**PRELIMINARY DRAINAGE REPORT
FOR
STERLING RANCH FILING NO. 5**

**March 2023
Project No. 25188.16**

**Prepared By:
JR Engineering, LLC
5475 Tech Center Drive, Suite 235
Colorado Springs, CO 80919
719-593-2593**

STERLING RANCH FILING NO. 5
PROPOSED DRAINAGE MAP
JOB NO. 25188.16
11/03/23
SHEET 1 OF 1

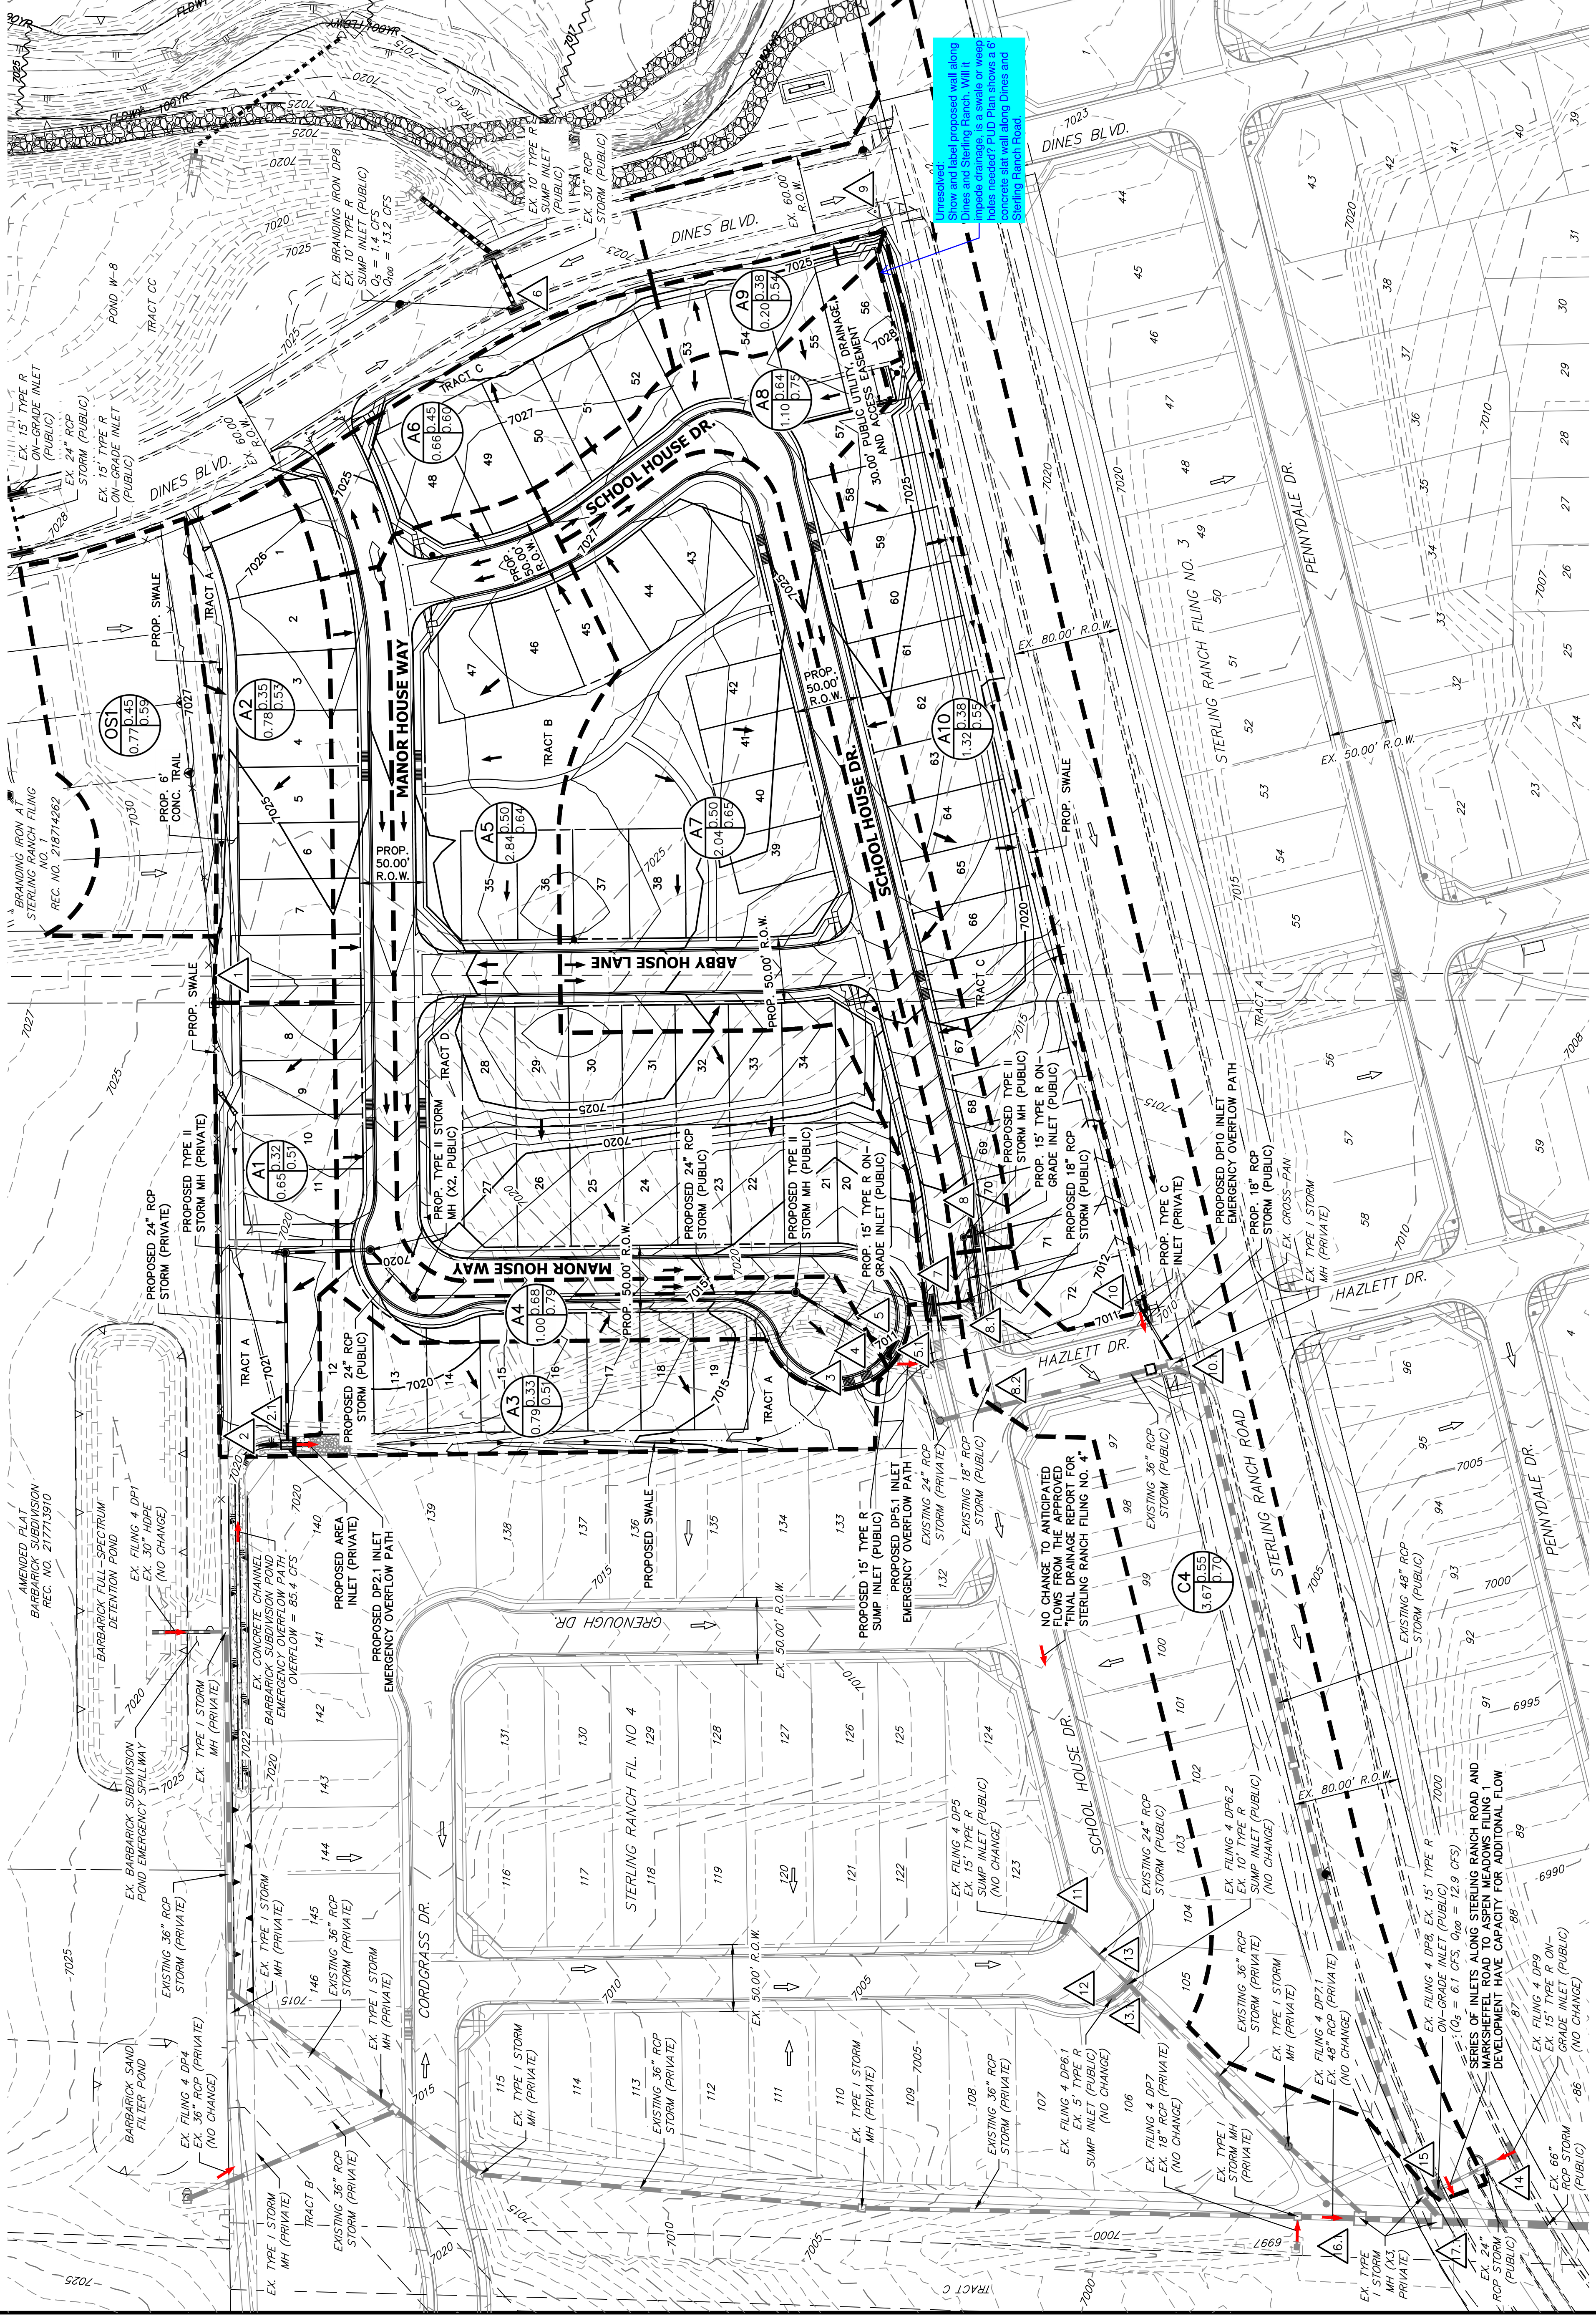
Show and label overflow path and swales on drainage map

Include discussion on overall flows exiting site and indicate if there is an increase or decrease to amount of flows entering existing storm system from Filing 5
